From: Andrew Wood
Sent: 02 April 2019 10:25
To: Planning.Responses
Subject: FW: Windroos LU/25/19/doc
Attachments: 063.5001.004D.pdf; 063.5001.105C.pdf

- Land within red edging to be within adoptable network (makes a turning head).
- Area with blue 'markings' to be removed from adoption area (we would need the access road north of it to make-up a turning head and given lack of available service margin it can't be used).
- E-W road reduced in width to 4.8m in order to accommodate a 1.0m wide service margin in front of the bank of parking alongside plot 62 (the service margin can't go through the parking spaces). The spaces themselves might need to move back slightly towards plot 62 as a consequence.
- Kerb lines adjusted as necessary.
- Although not shown, the path running to A259 from southern turning head of the internal roads (so that by plot 22) might also need to be taken as adopted. However, the final decision about this can be made at the S38/278 stage.

Principal Planner, Highways – Planning Services

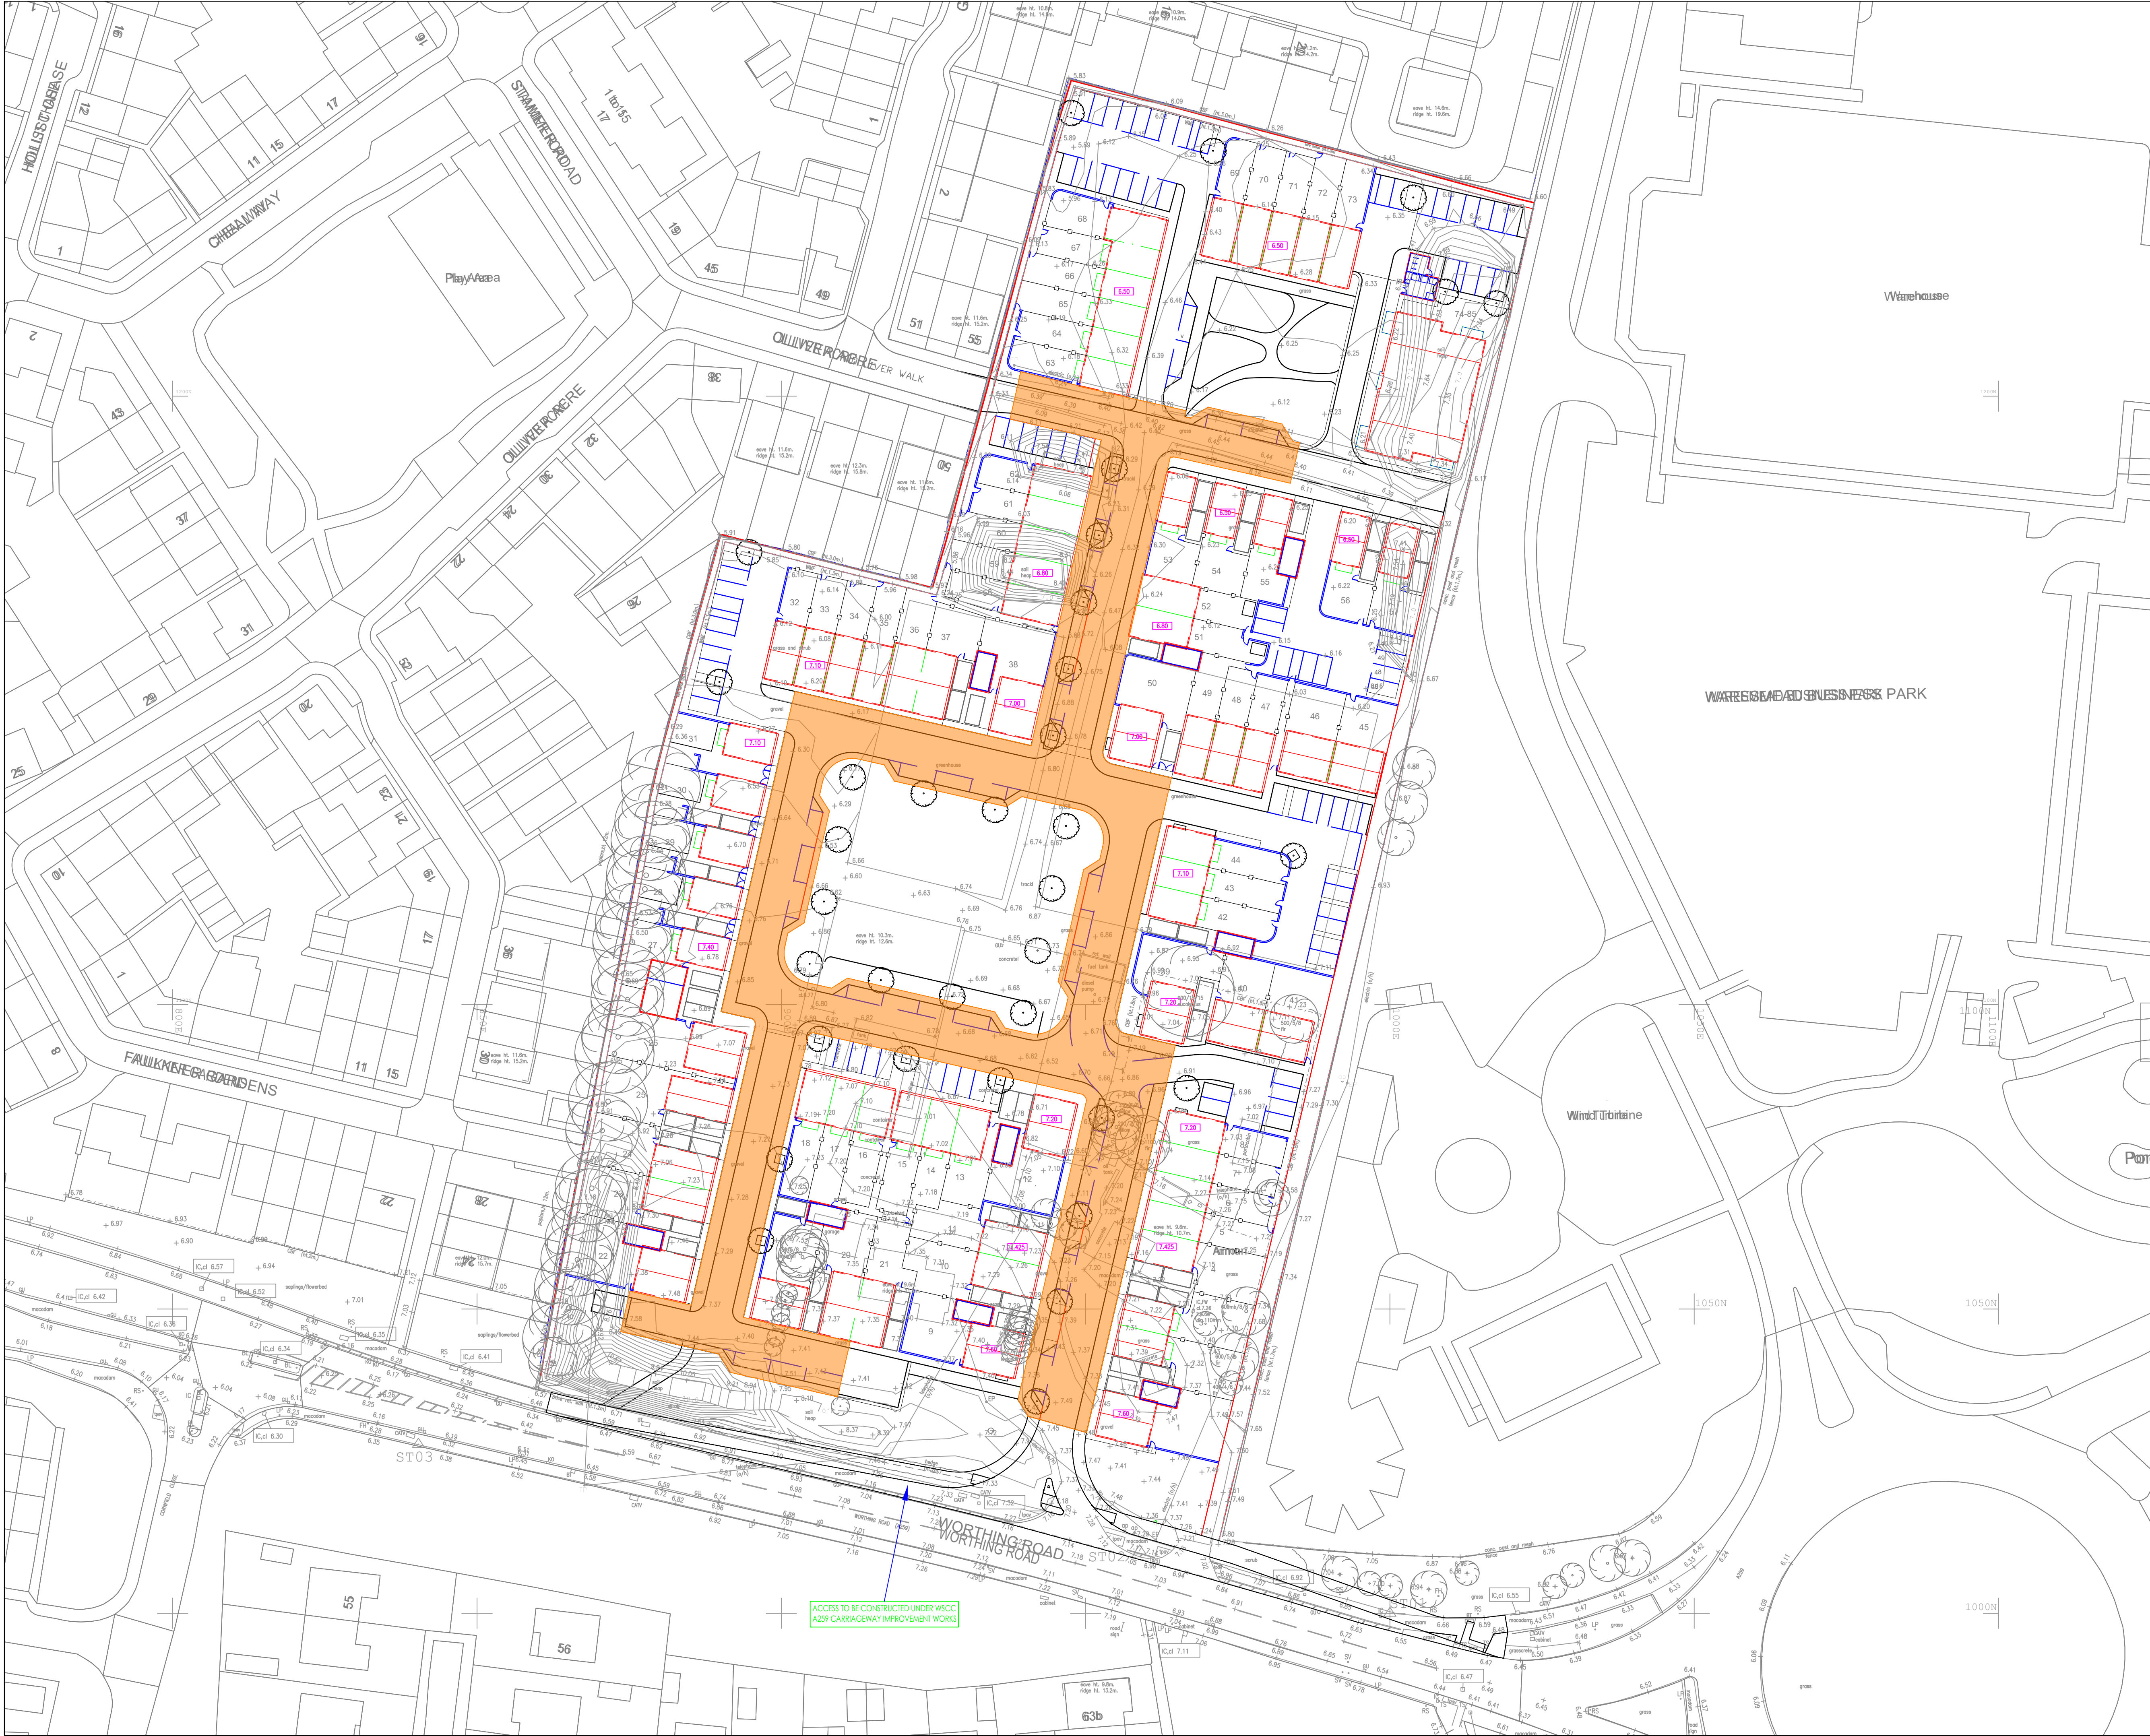
Yep -- that's it. Just make sure you still get a margin around the eastern side too as that seems to have disappeared from the version shown below.

No quite. The service margin on the western side by the car parking spaces needs to be clear of the carriageway and the car parking spaces might need moving-back slightly so they don't overlap it. If you simply adjust the southern kerb line to follow the edge of the carriageway and NOT the back of the service margin and return it to match the 5.5m wide road coming-in from the west – that should do it I think.

Many thanks for the prompt response. How is the below? The parking bays are pushed south slightly to allow for the 1m service margin and a 4.8m CW width, and as you mentioned the kerbline realigned to run at the edge of the carriageway not the back of service margin (and also in line with the eastern road southern kerbline)

1. Internal paths on POS removes.
2. Path down to Worthing road added.
3. Service margins of 1m minimum.
4. As service margins could not be achieved at north of site without moving building location- adoption area removed.
